RE: Planning application AW/353/14/PL - No. 11 Marquis Way PO21 4AT

Planning application reference AW/353/14/PL

RE: Planning application AW/353/14/PL

project: 11 Marquis Way - Aldwick			
drawing title: Proposed Site Plan			
drawing status: Planning Application			
date: 09 - 12 - 2014	scale at relevant drawing size 1 : 50 (A1) or 1 : 100 (A3)	no: JW131105 - PL10	rev.: -

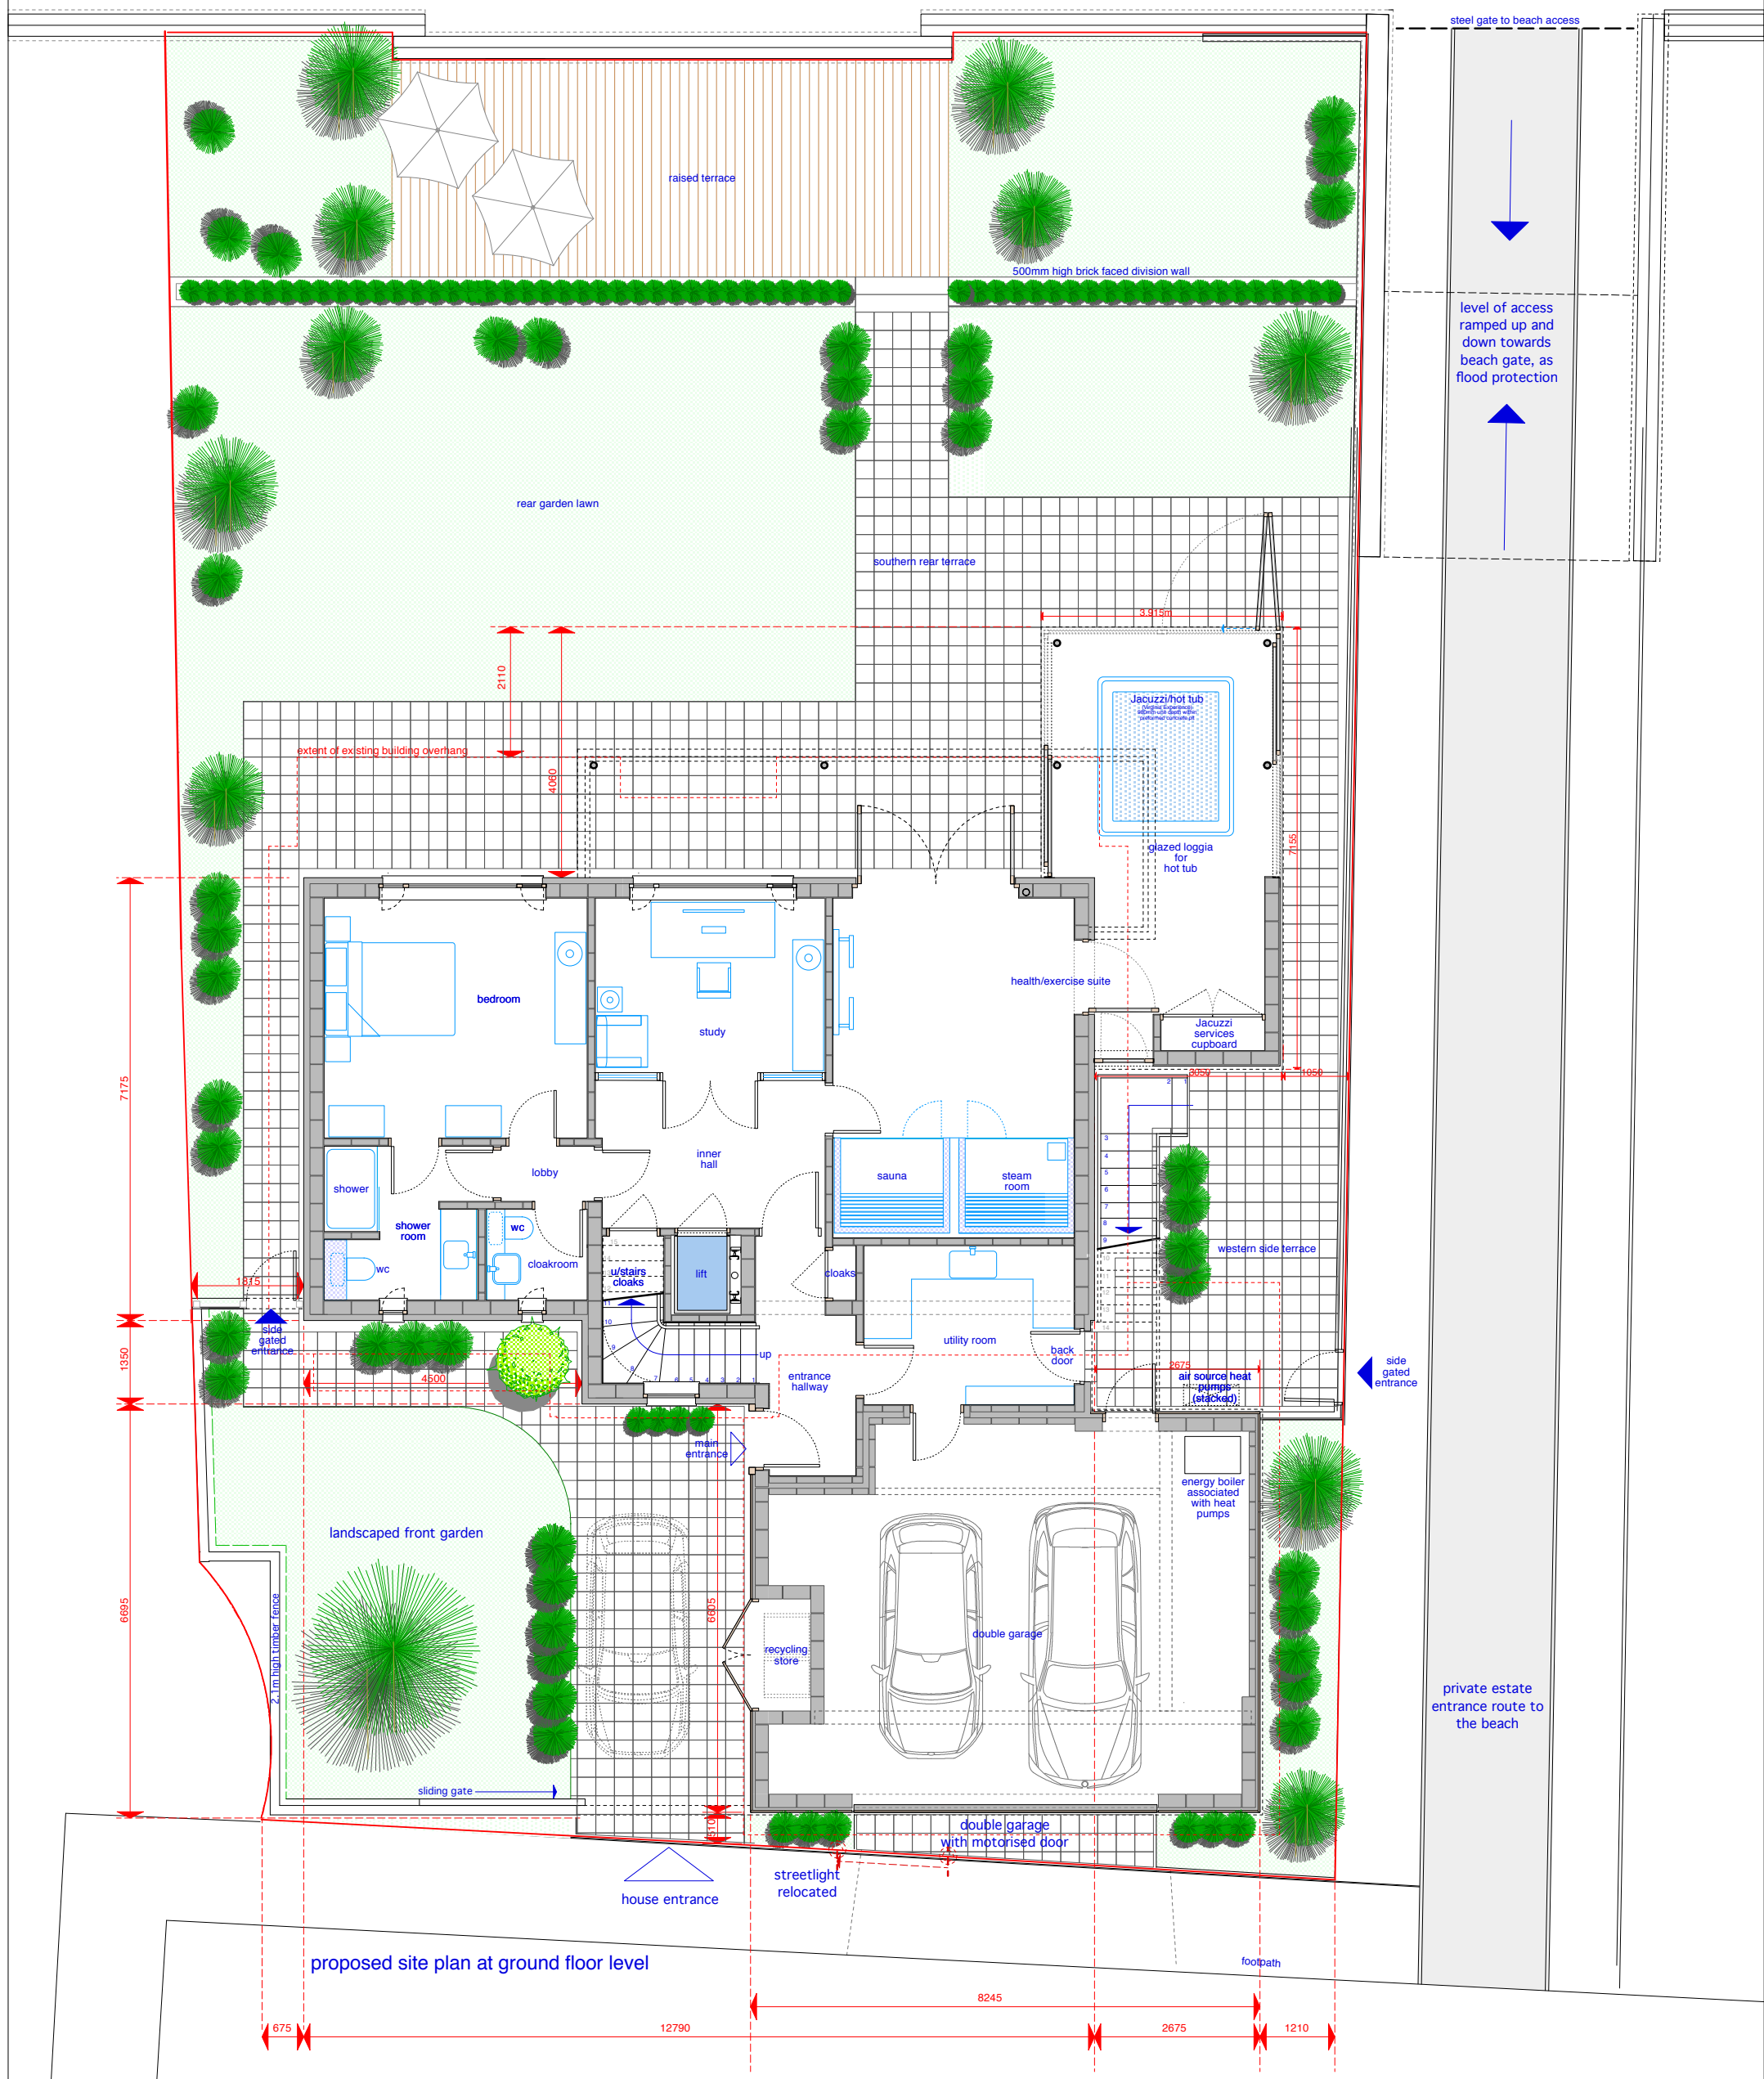
In addition the plans show that the south and west facing elevations extend beyond the existing line. The south facing building line was enforced when planning approval was granted for the extension to No.15

1. **Design and Appearance.** The design and resulting appearance of a flat roofed, rendered house with extensive first floor balconies will differ from all other properties which are constructed of brick with a pitch roof of either slate or concrete tile. The plans show that the south and west facing elevations extended beyond the existing line. The south facing building line was enforced when planning approval was granted for the extension to No. 15.

project:	11 Marquis Way - Aldwick		
drawing title:	Existing and Proposed Parking Plans		
drawing status:	Planning Application		
date:	09 - 12 - 2014	scale at relevant drawing size	1 : 100 (A1) or 1 : 200 (A3)
no:	JW131105 - PL16	rev:	-

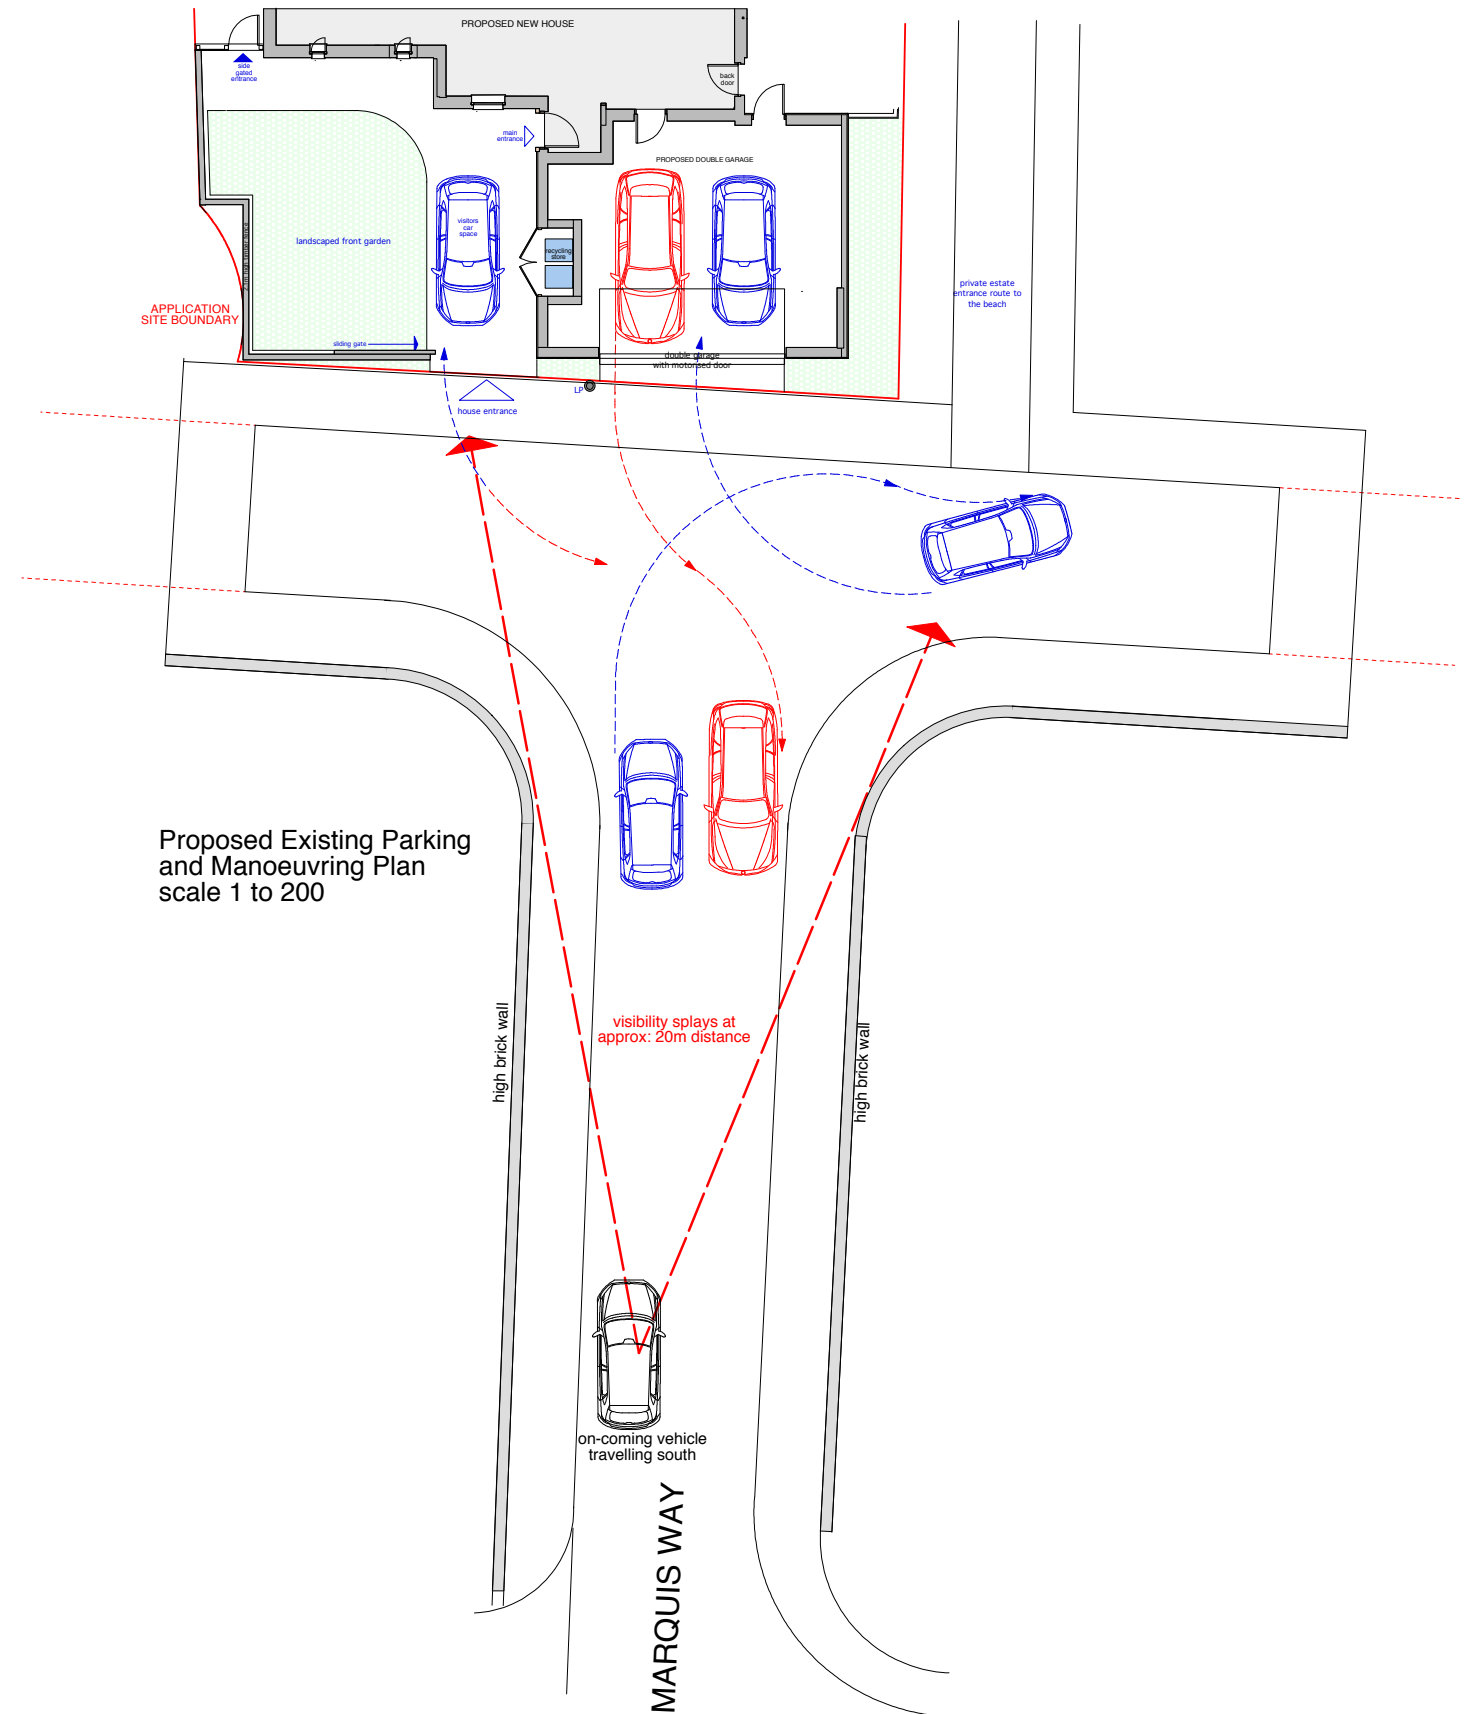
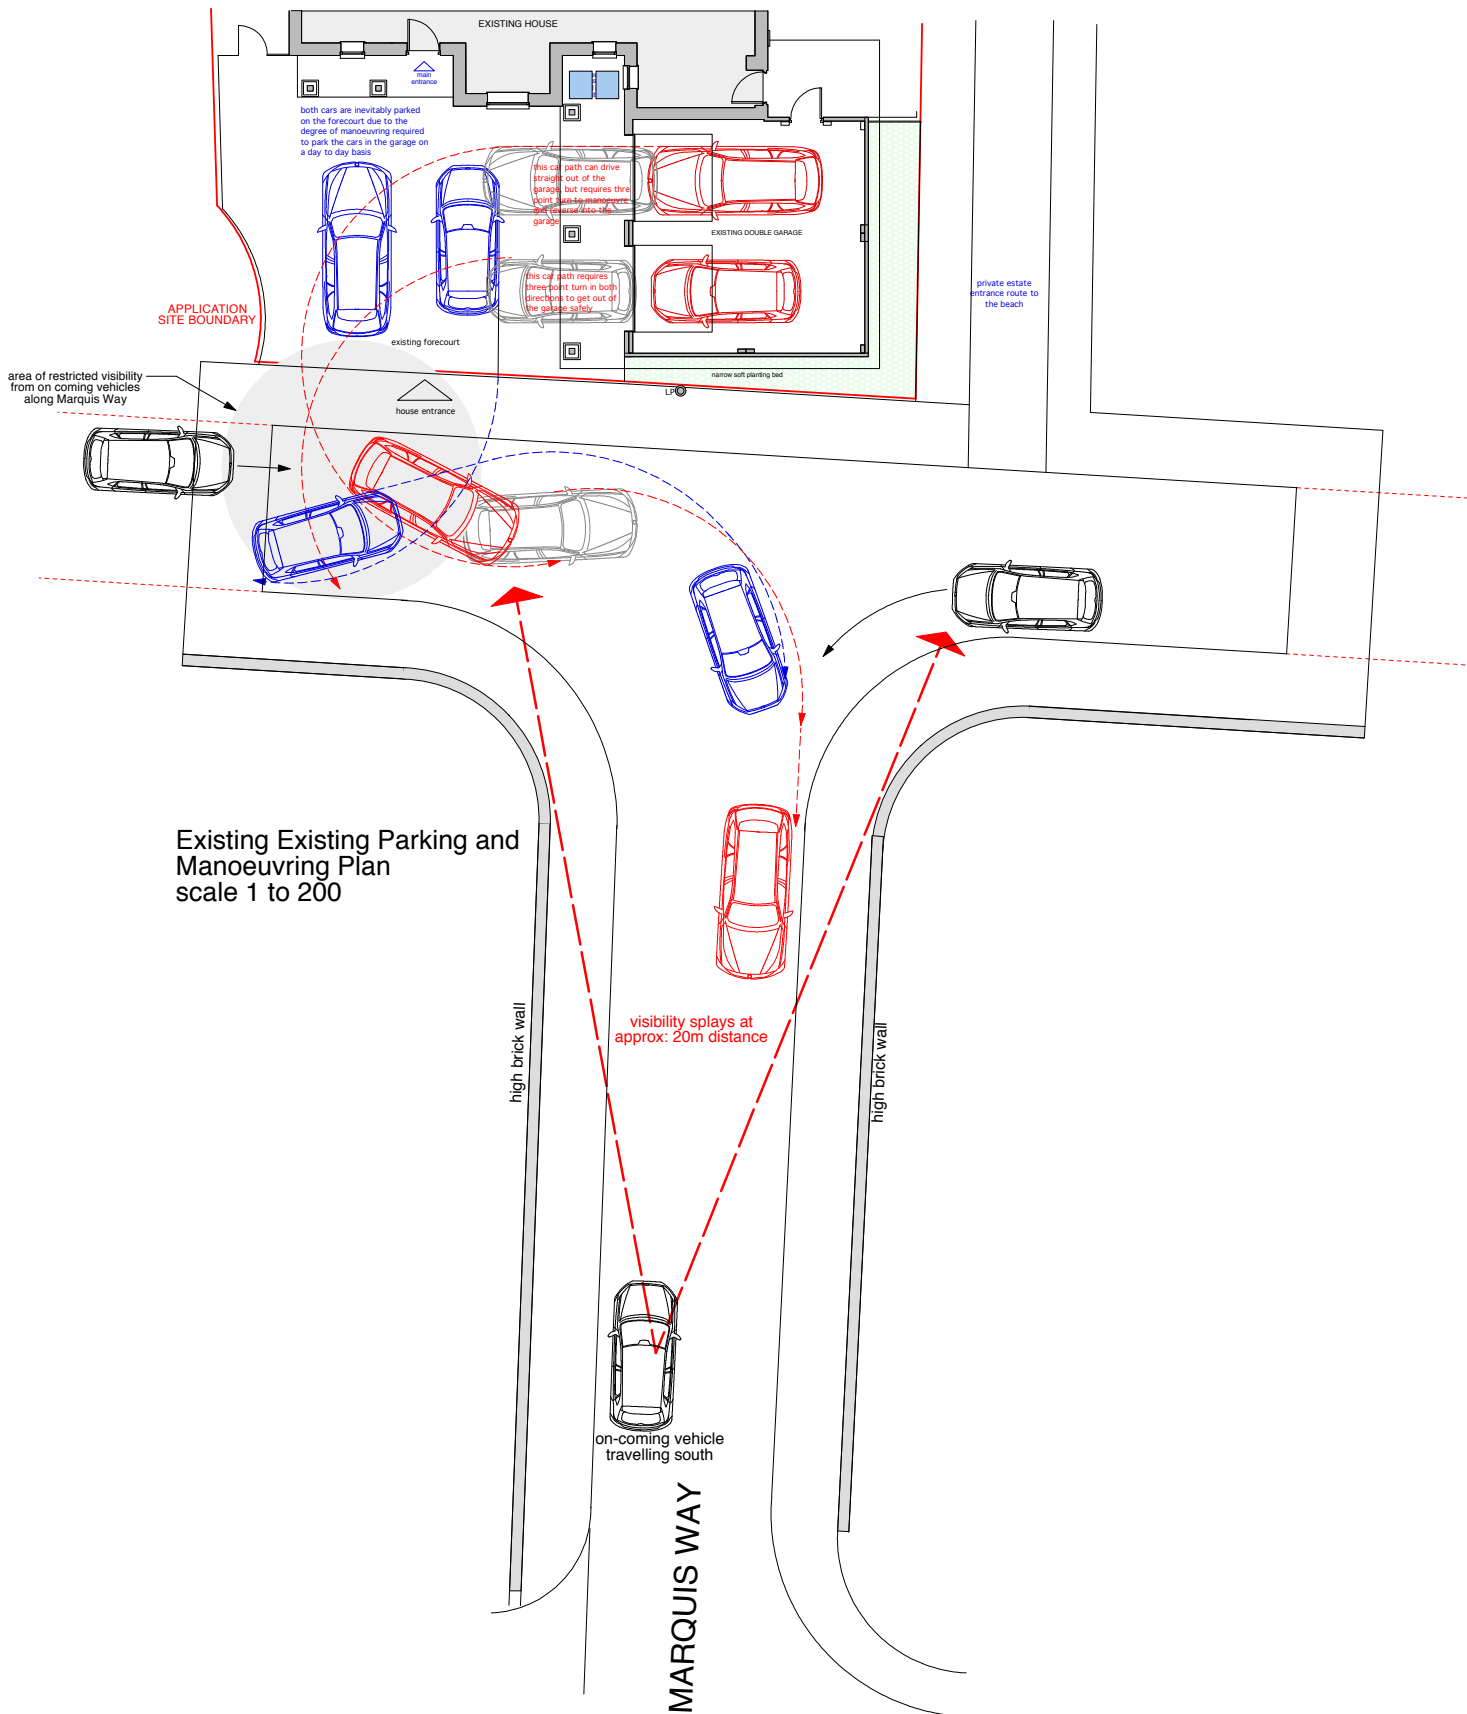
The proposed design shows that cars will drive straight out of the garage on to the road instead of at present onto the parking area in front of the house. This raises a safety issue for at least five other residents using this section of the estate road

- a. The design shows that cars will drive straight out of the garage on to the road raising a safety issue for 5 other residents using this section of the estate road.

project:	11 Marquis Way - Aldwick		
drawing title:	Proposed Sections A and B		
drawing status:	Planning Application		
date:	scale at relevant drawing size	no:	rev:
09 - 12 - 2014	1 : 50 (A1) or 1 : 100 (A3)	JW131105 - PL19	-

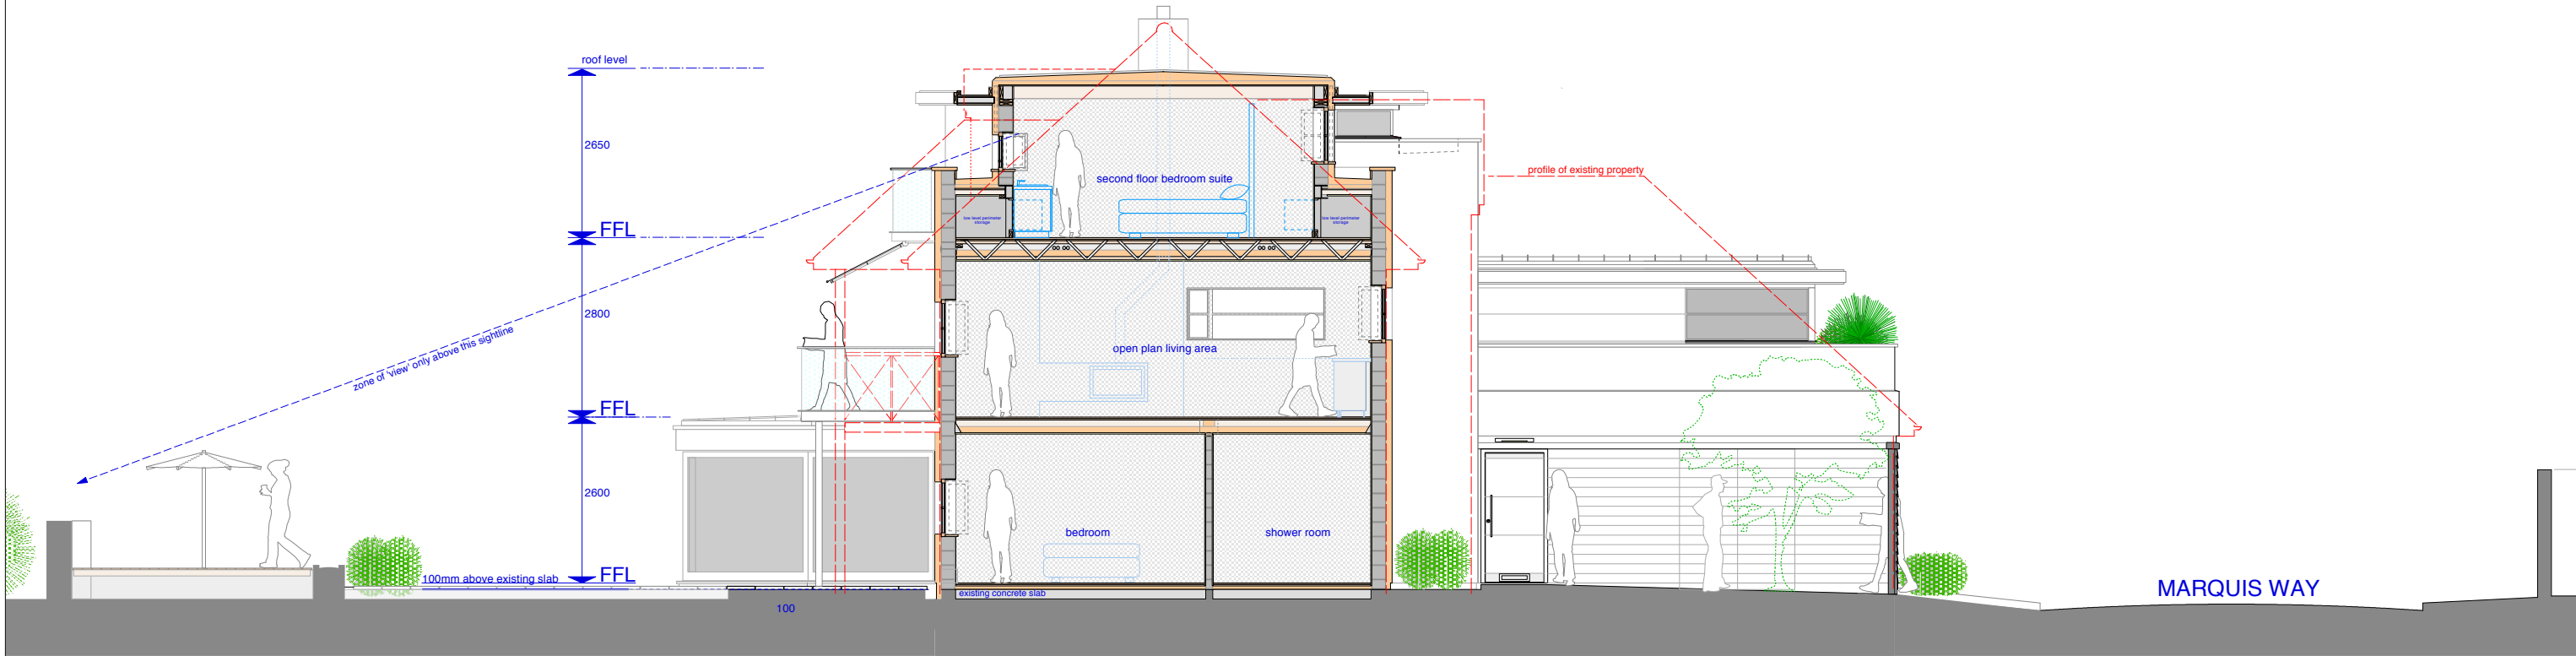
Several properties not currently overlooked in any meaningful way will be as a result of a first and second floor north and west facing balcony.

4. **Privacy.** Several properties not currently overlooked in any meaningful way, will be as a result of a first and second floor north and west facing balcony. This is of particular concern to ourselves as at present there is no ability for No 11 to look over our garden, whereas, with the new design, people on the external staircase and balconies will have clear views of the rear of our house.
